# **THE STAR MODIFICATION 14 (MP 08\_0098)**

## **HERITAGE RESPONSE TO COMMENTS**

Urbis has been engaged by The Star Entertainment Group to prepare the following response to the comments pertinent to Modification 14 (MP 08\_0098 MOD14) which involves various additions and alterations to The Star Casino. This report is primarily concerned with works which have the potential to visually or physically impact on The SELS building which is located in the northern west corner of The Star.

2 PANTRY SECTION  
A7018 1:20

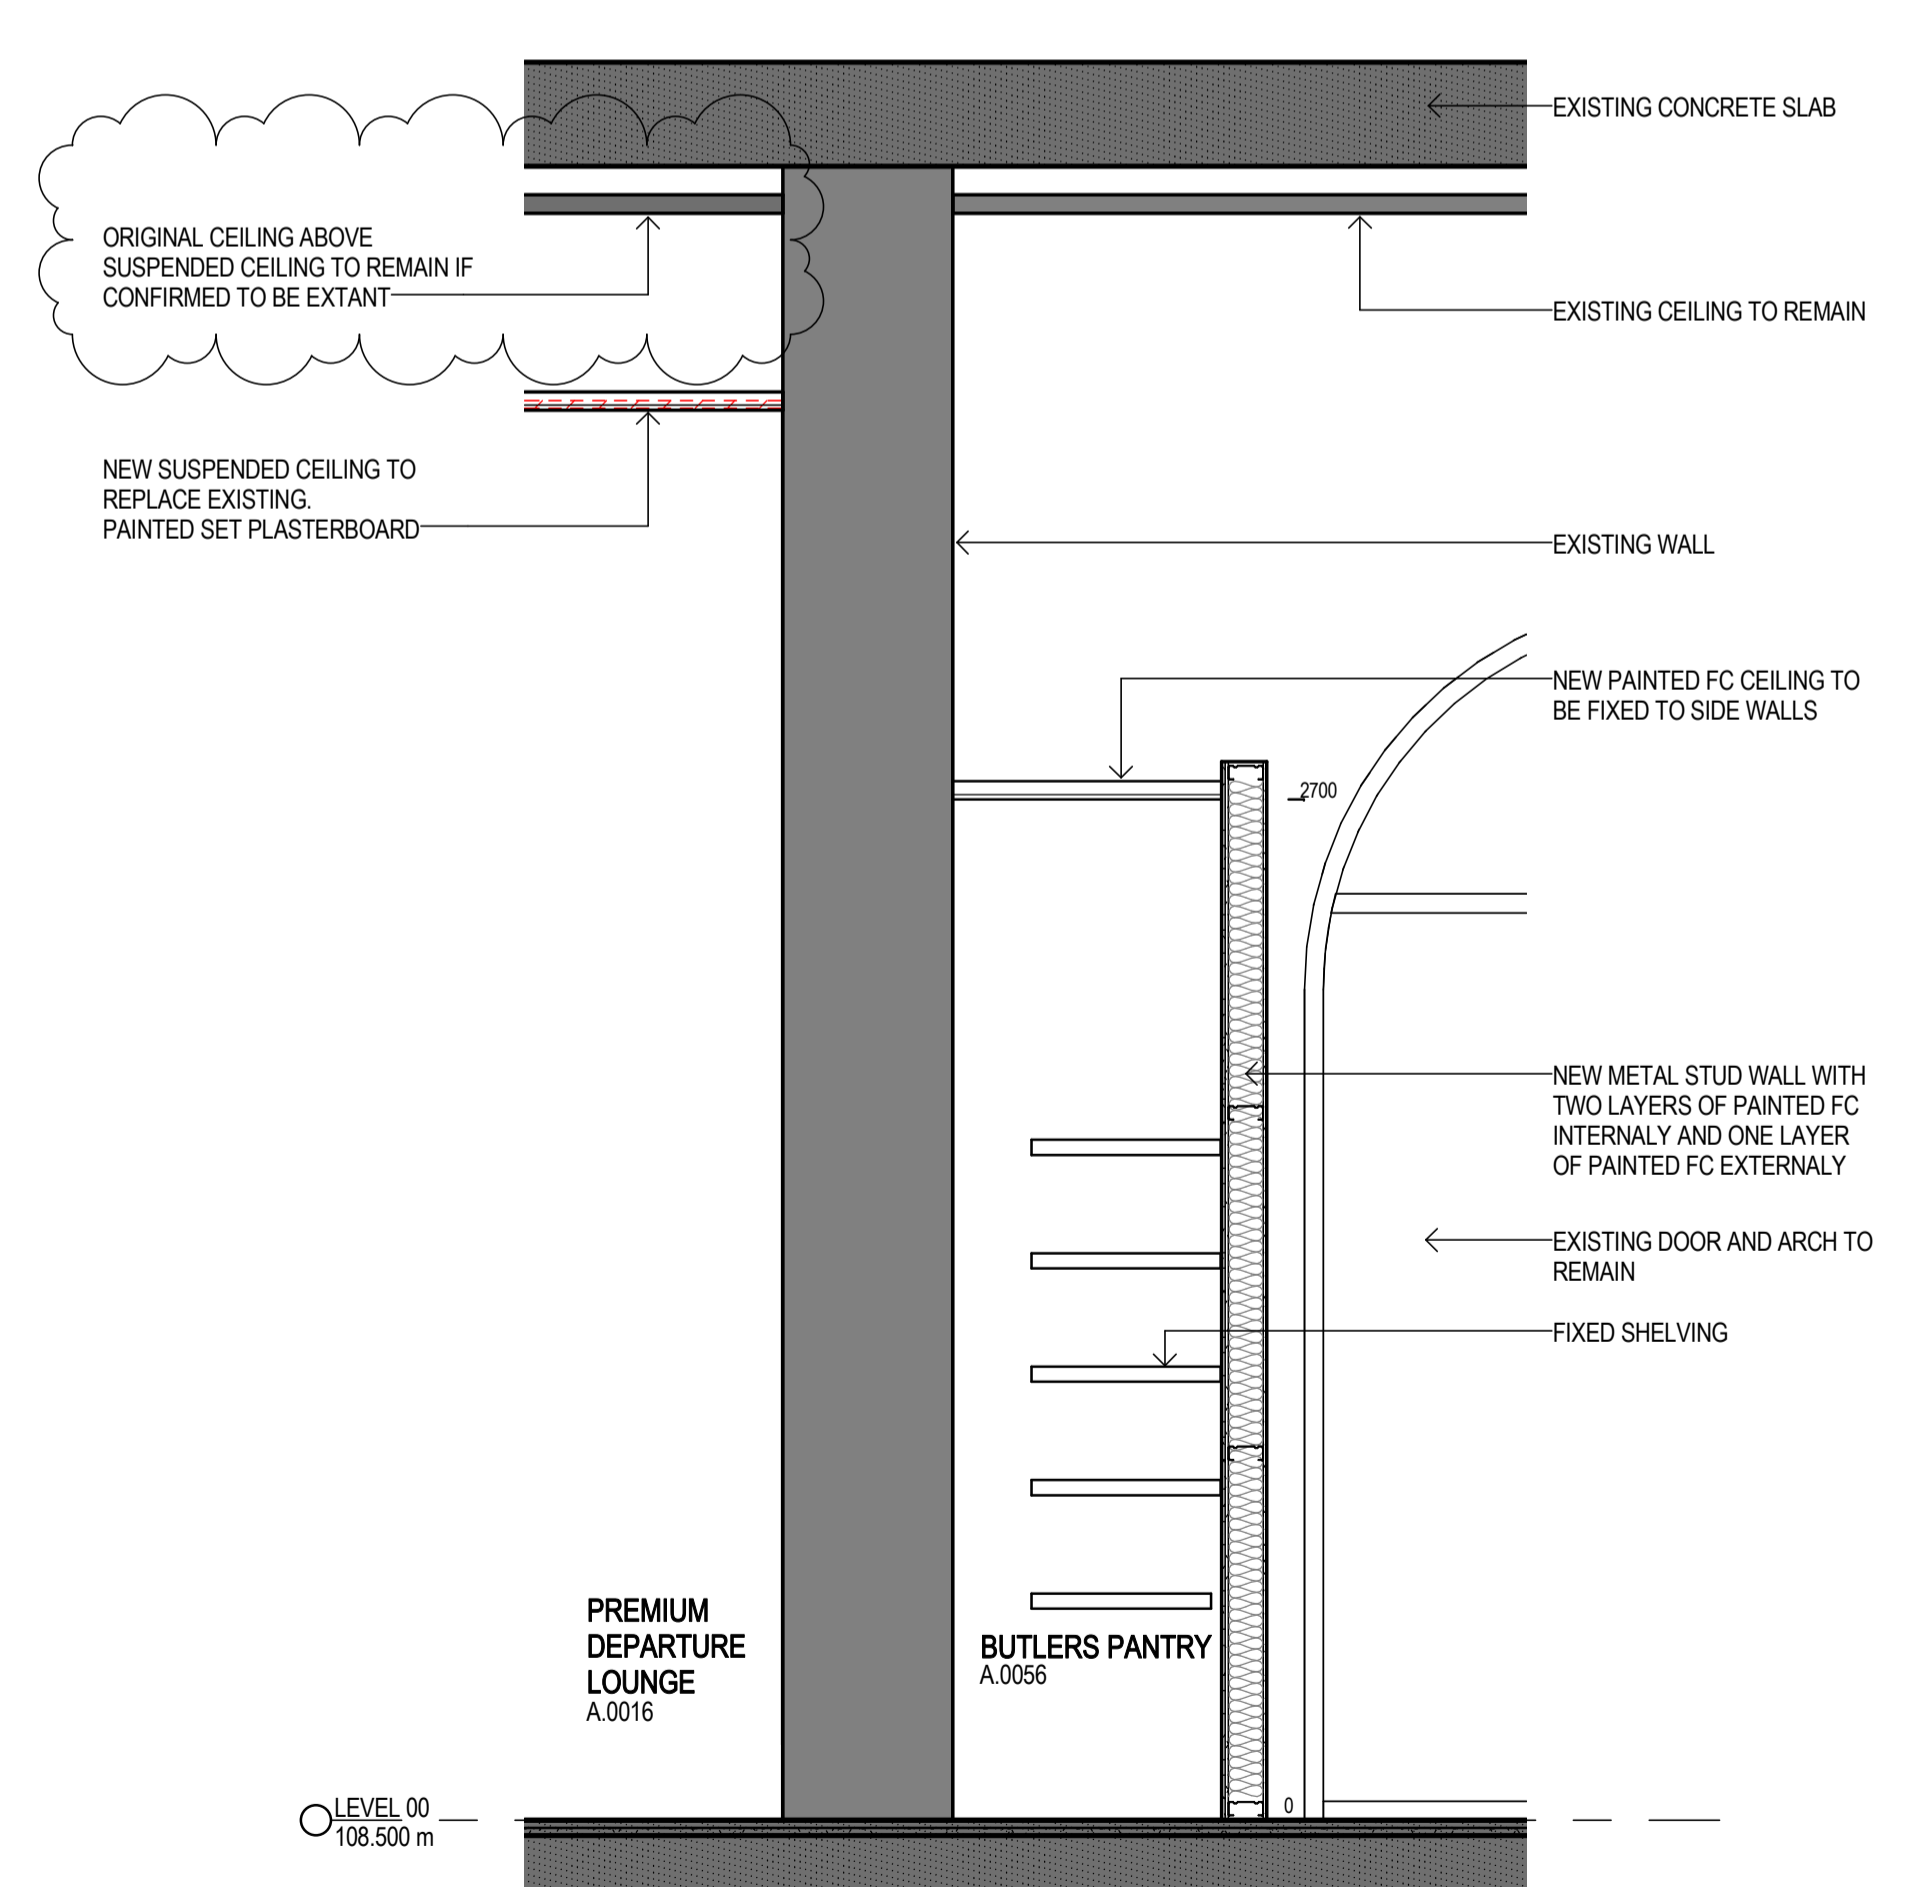
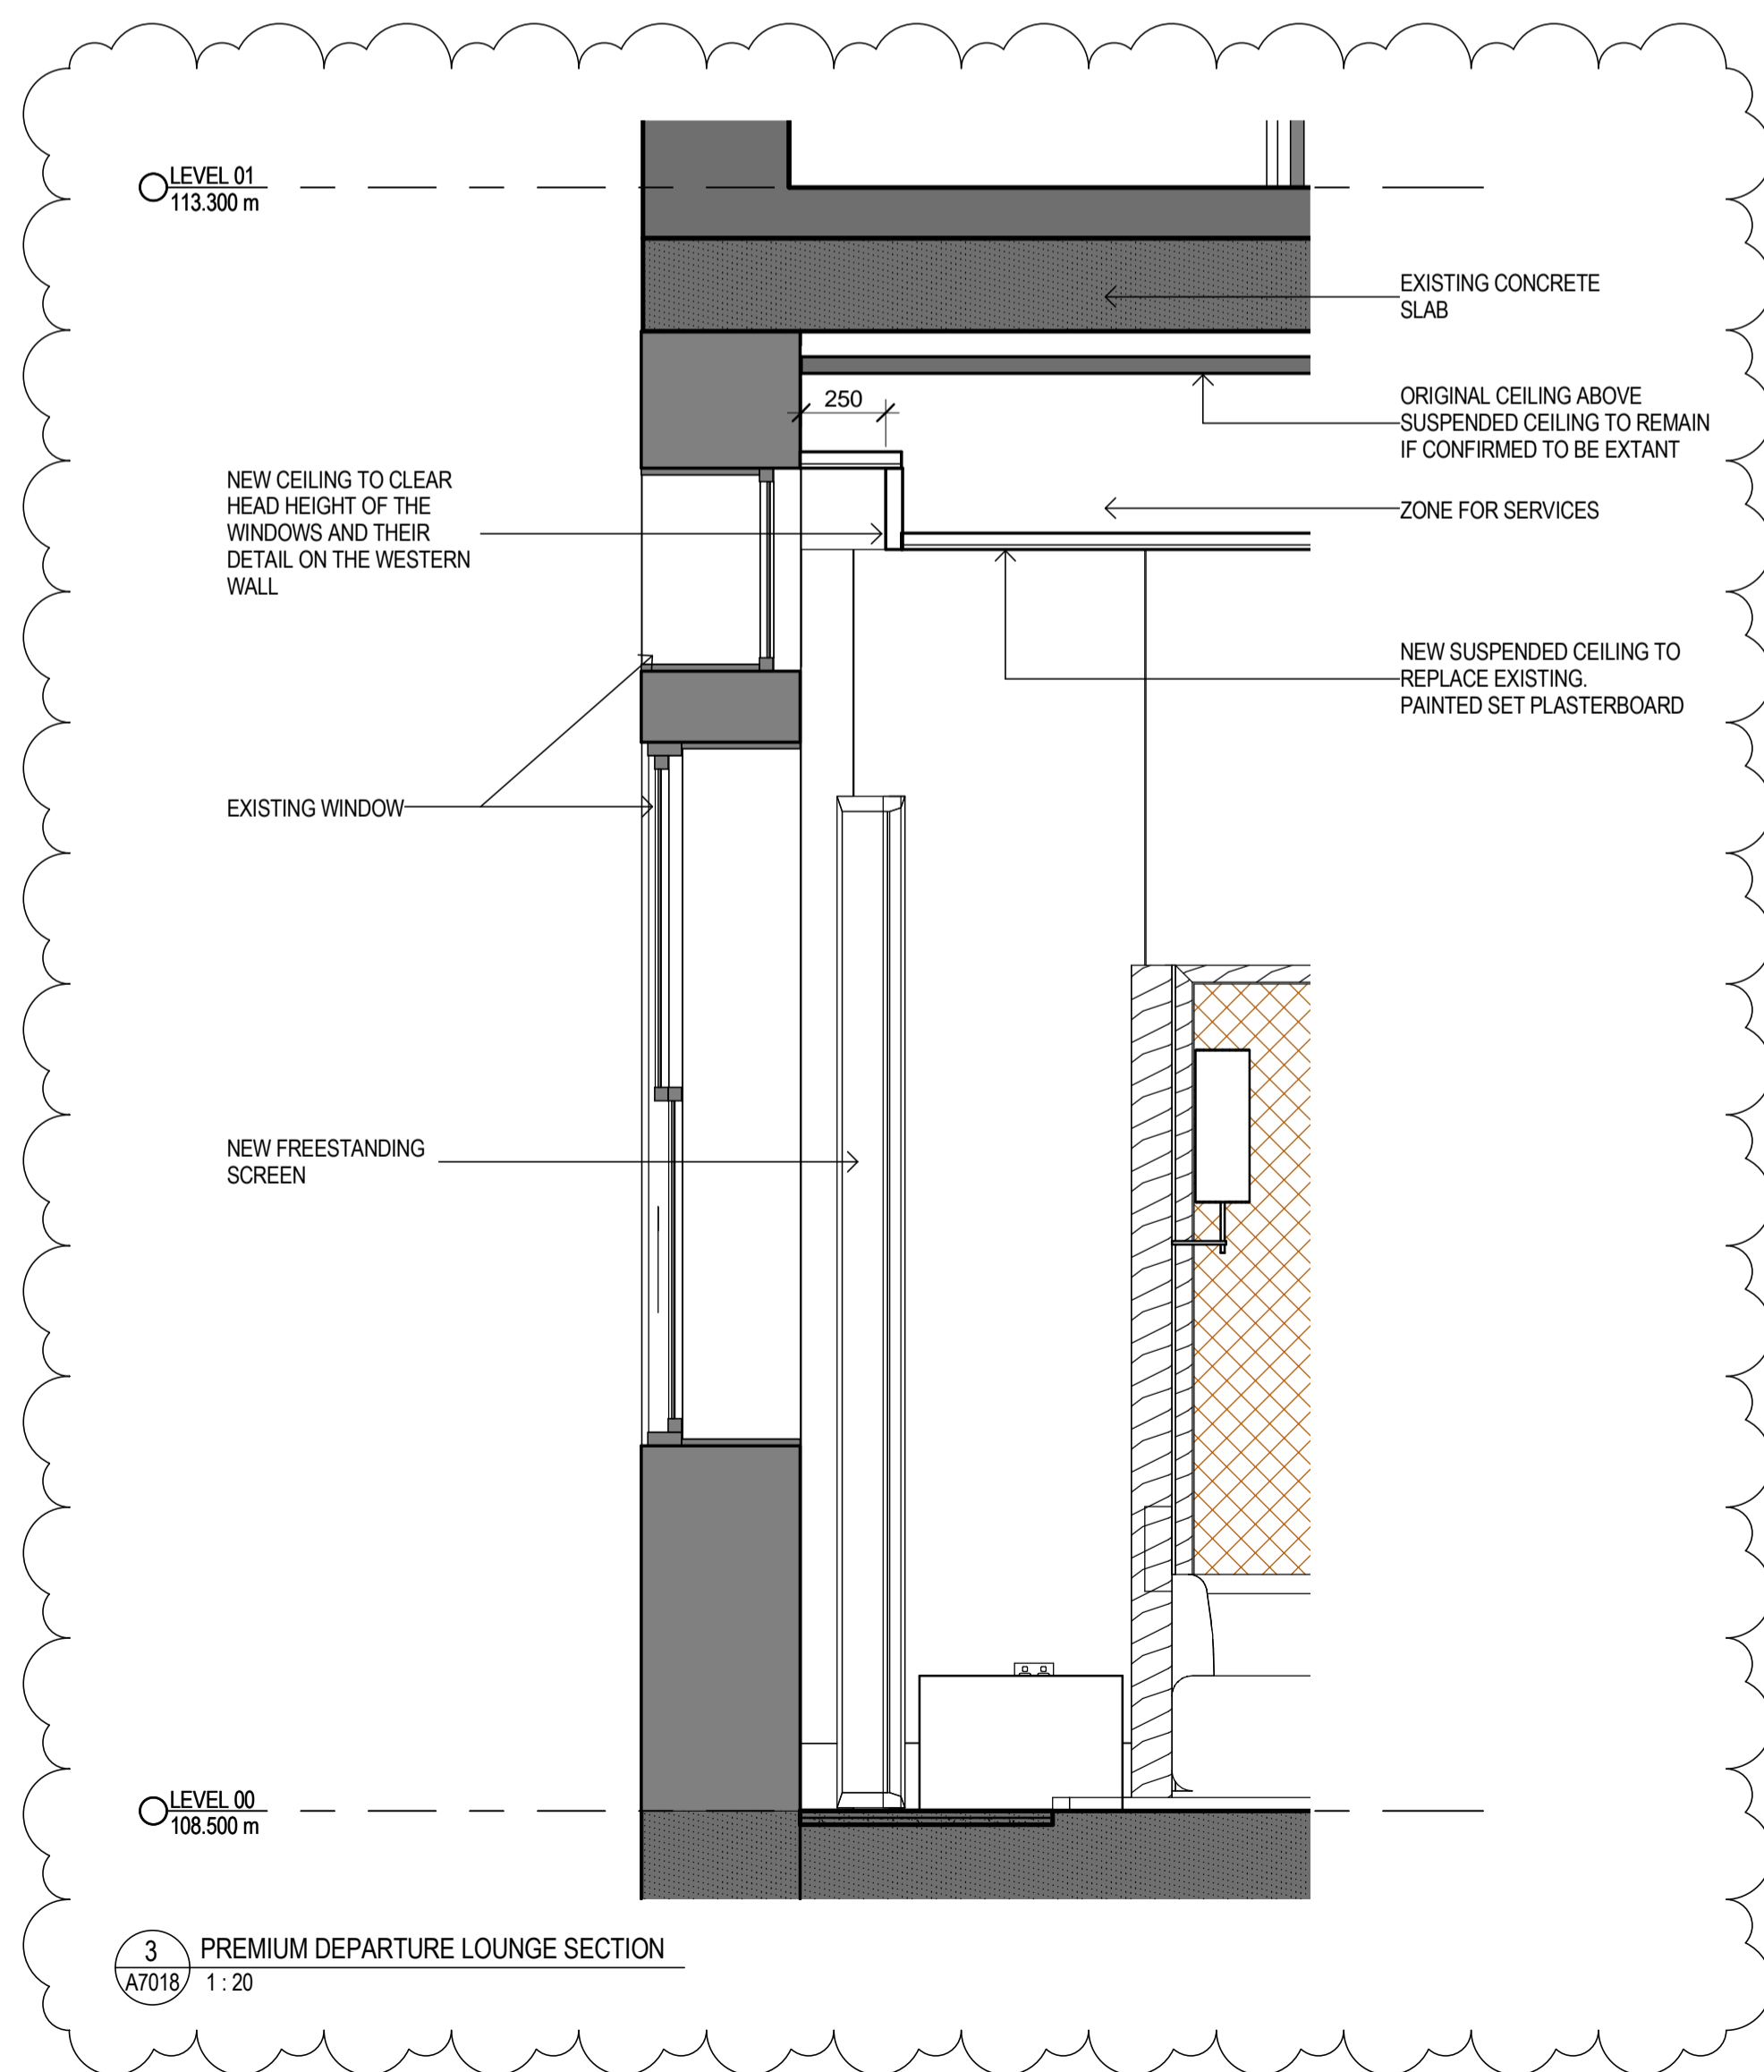
**(Refer Section 3.6 below for discussion).**
- *With regard to the arrival lounge, the demolition plan is unreadable and the proposed changes are difficult to decipher. Clear detail of the demolition and the changes being proposed should be shown on the drawings, including section, which should include the extent of demolition, lightweight construction of the new partition for the butler’s pantry and other changes to the room layout, removal of the suspended ceiling, details of screening etc.*

- *All works for the new Butler's Pantry will be through lightweight reversible partitions and a low ceiling so that existing hallway cornice can be viewed and the works can be removed in the future with minimal damage to the fabric.*

The new works largely include the addition of freestanding furniture into the room. The new butler's pantry would be lightweight and would not obscure the significant original door to the adjacent room.

The new ceiling would be at an appropriate height which would clear the head height of the windows and their detail on the western wall.

The Butler's Pantry would be constructed of lightweight reversible partitions (refer 303448\_A7018 prepared by DWP Suters).
